## WEST SUSSEX COUNTY COUNCIL CONSULTATION

| <b>LOCATION:</b>                | 1-20 Churchill Parade, 125-166 The Street 103-133 The Street, Churchill Court, Rustington                              |
| <b>SUBJECT:</b>                 | R/185/20/PL<br>New external canopies to store fronts. These sites are in CiL Zone 4 (Zero Rated) as other development. |

PROPOSED SITE PLAN
1:500

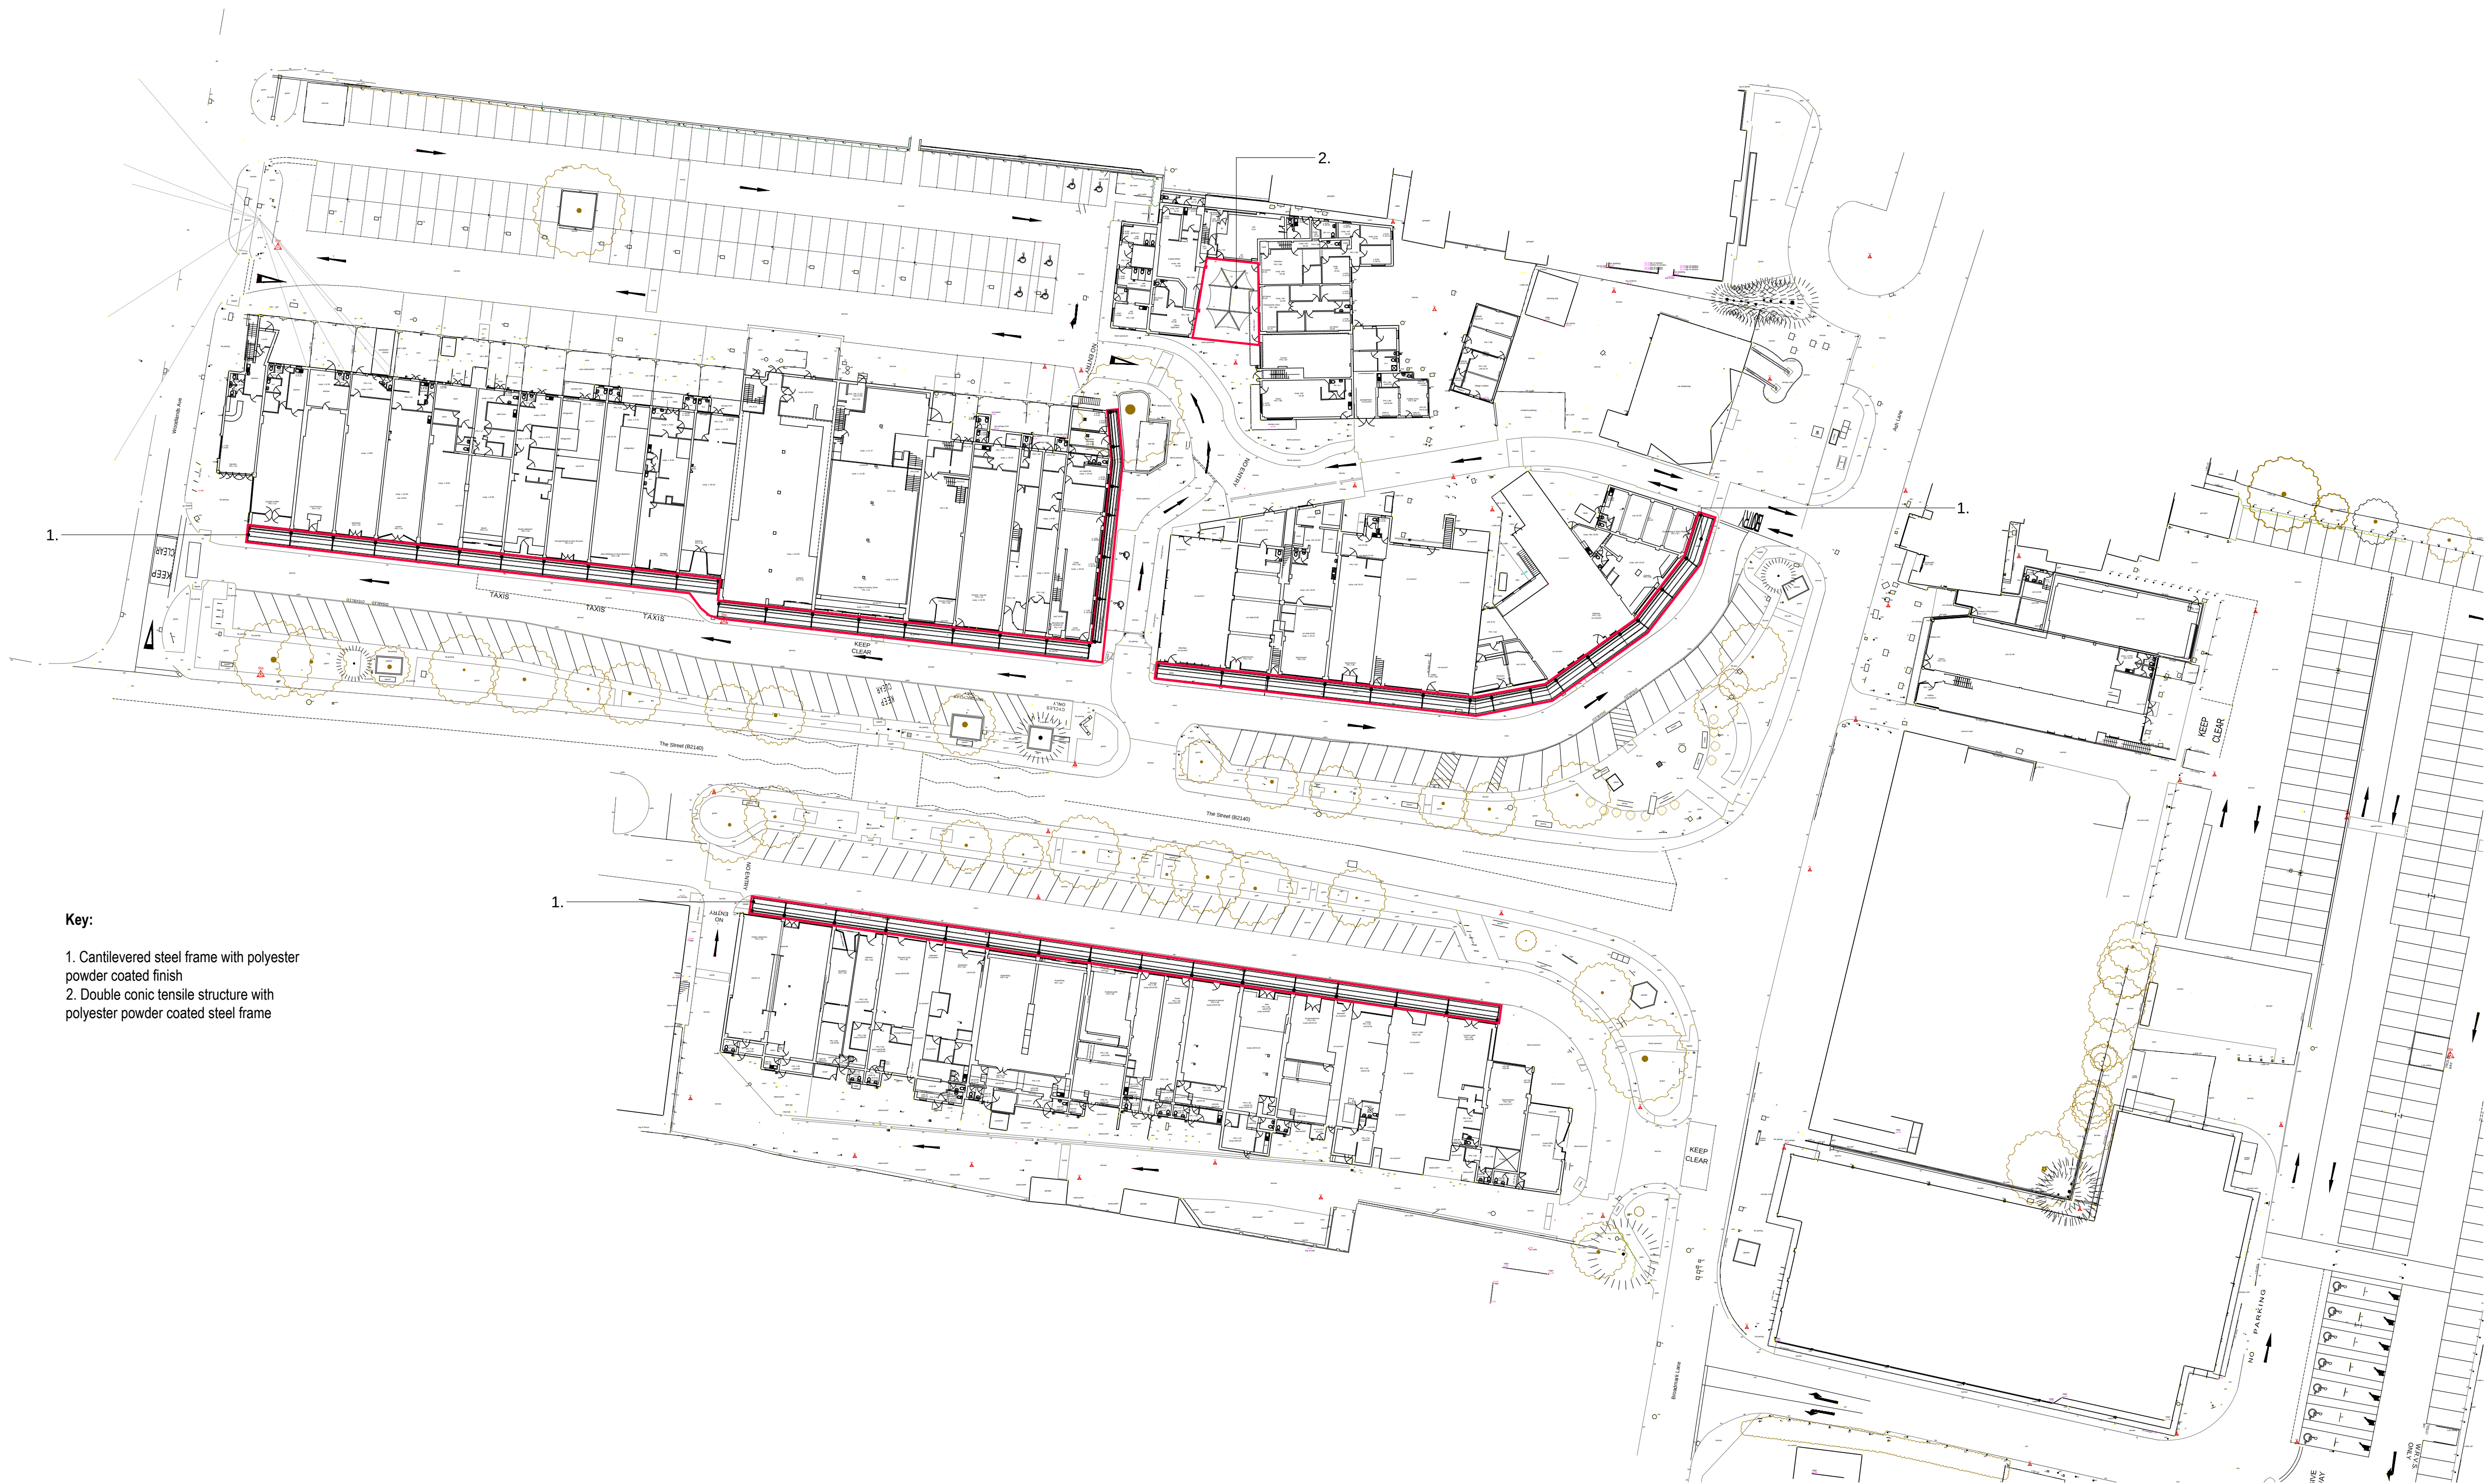
From inspection of the plans and local mapping, the proposed canopy will overhang publicly maintained highway. Therefore, the applicant will have to obtain a Section 177 Licence from WSCC. The applicant should also obtain formal consent for any proposed works within the maintained highway. (See below informatives).

PROPOSED TYPICAL
STREET ELEVATION & SECTION

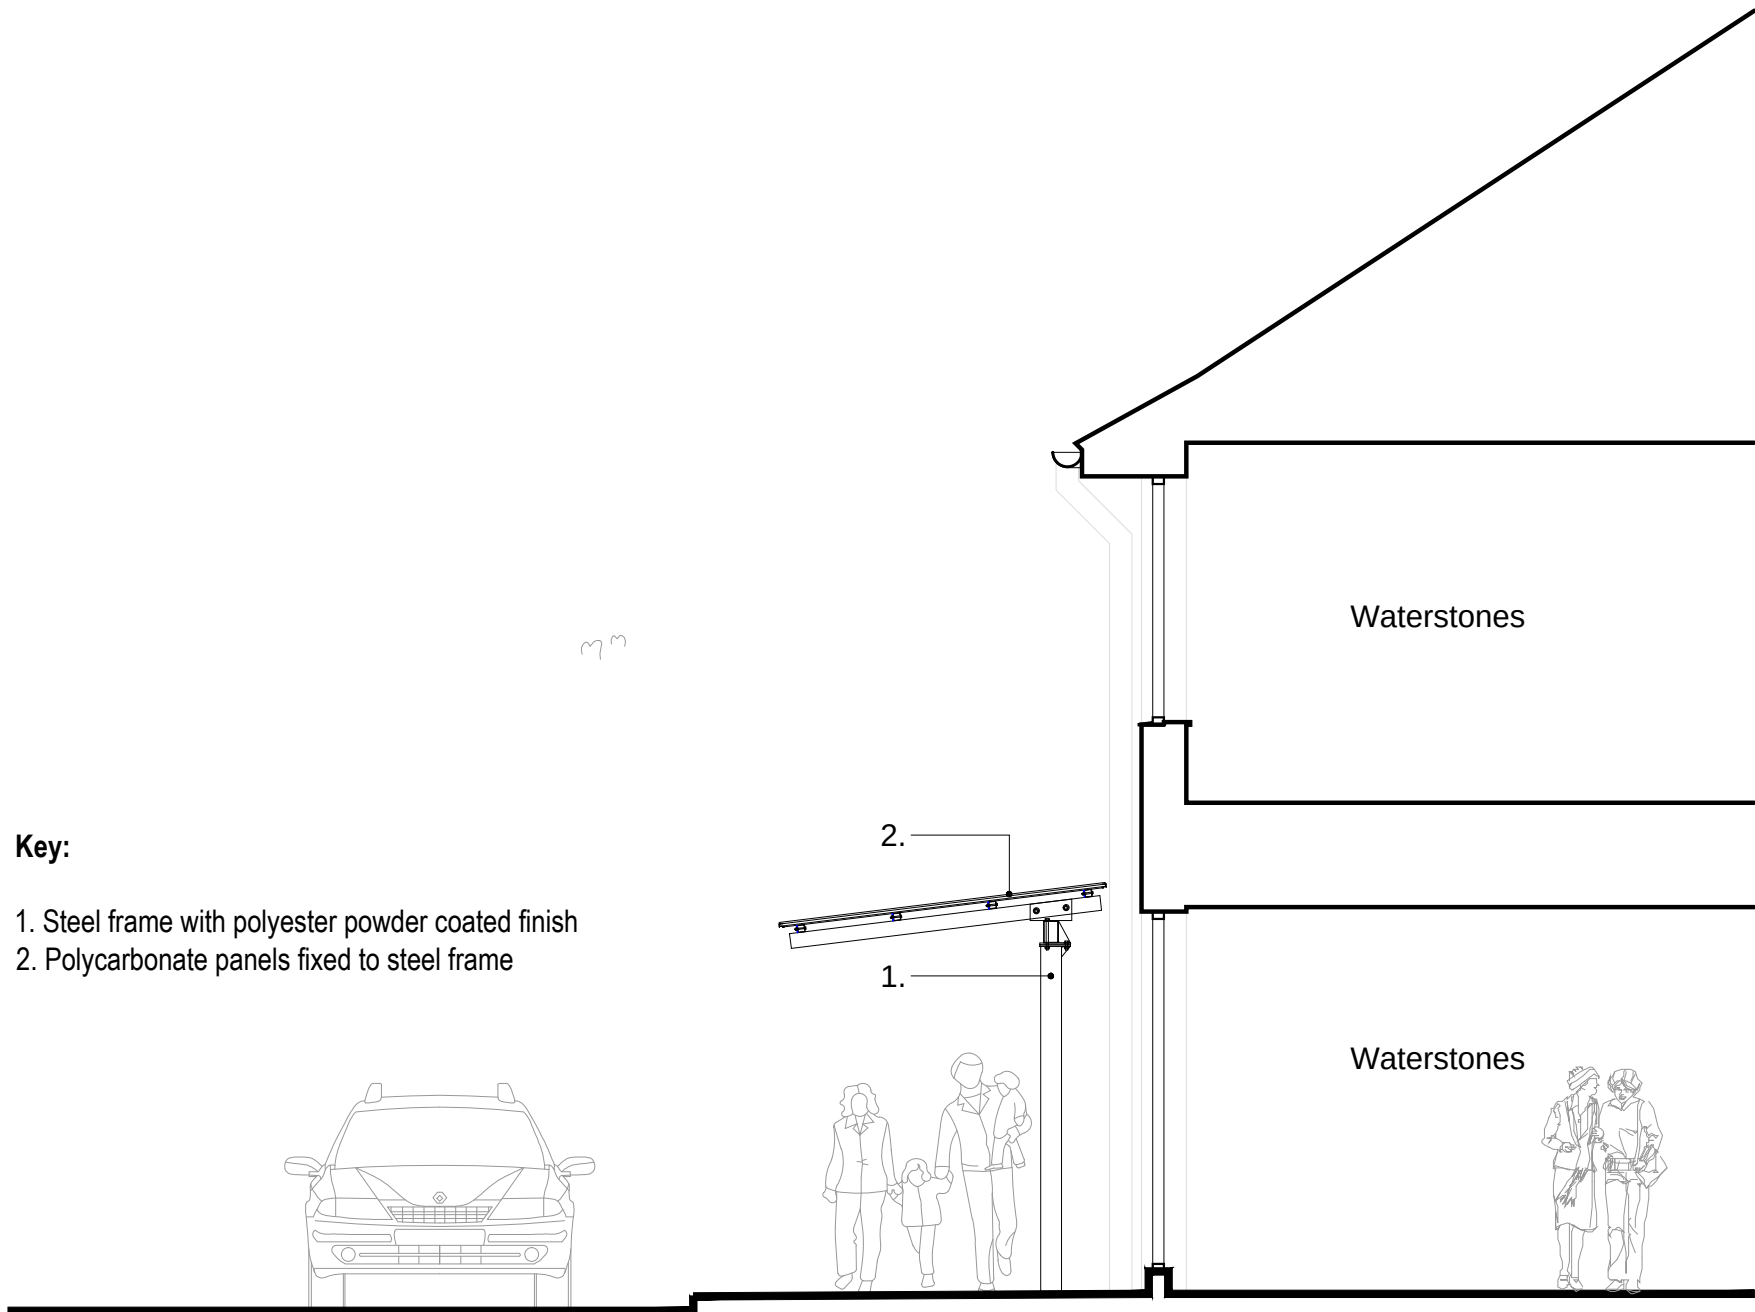
The applicant should be aware that there must be a minimum of 2.4 metres height clearance between the footway level and the underside of any projecting awning. In addition, the outer edge of the awning should be, no closer than 500mm from the vertical projection of the carriageway edge. The plans suggest that the proposed canopy meets these minimum requirements.
